KITTITAS COUNTY

MEMORANDUM

TO: All Staff
FROM: Public Works Plan Review Team
DATE: October 1st, 2024
SUBJECT: SPF-24-00007 Mohar

DWN BY: D.L.P./G.W.
SCALE: 1" = 200'
CHECKED BY: D.L.P./M.K.K.
SHEET 1 OF 3

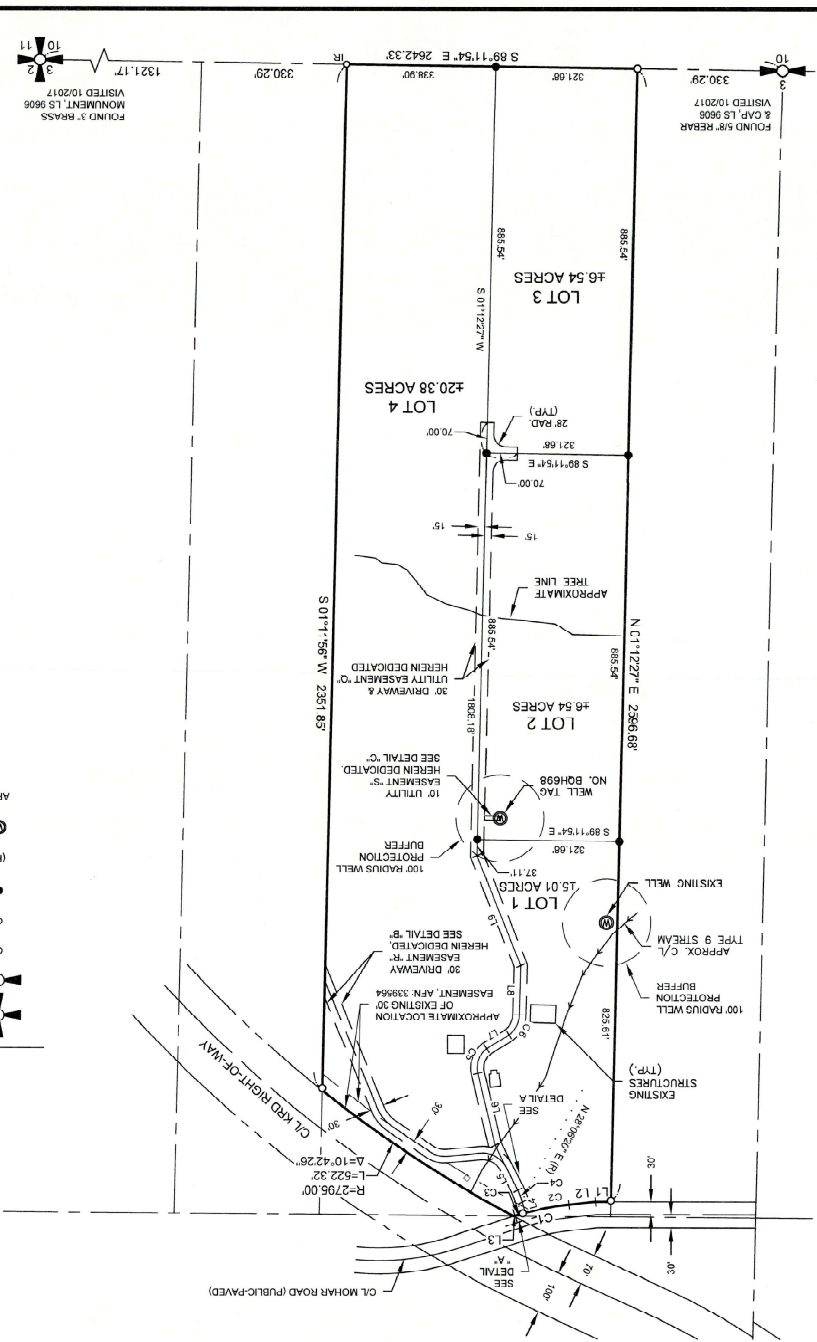
SURVEY	<ol style="list-style-type: none">1. Please include a note or label to address the Basis of Bearing.2. Please clarify that the lands located North of Easement "R" are a part of Lot 4.3. Please include suitable dimensions to locate the southern terminus of Easement "Q".4. There is a typo in Note 9 "bee". (JT)
TRANSPORTATION CONCURRENCY	No transportation concurrency management application is required for this project. (KAH)
FLOOD	No comments. (SC)
WATER MITIGATION/ METERING	<p>A plat note must also be added for the conservation easement:</p> <p>LOT 3 OF THIS SHORT PLAT HAS BEEN PLACED IN A CONSERVATION EASEMENT RECORDED UNDER AFN 202409250024, THAT STATES LOT 3 SHALL BE USED FOR OPEN SPACE AND NO DOMESTIC WATER CONSUMPTION OR USE SHALL OCCUR. SEE DOCUMENT FOR FULL DETAILS.</p> <p>Please also include a note on the face of the plat in lot 3 that states: see short plat note <u>(insert number here)</u></p>
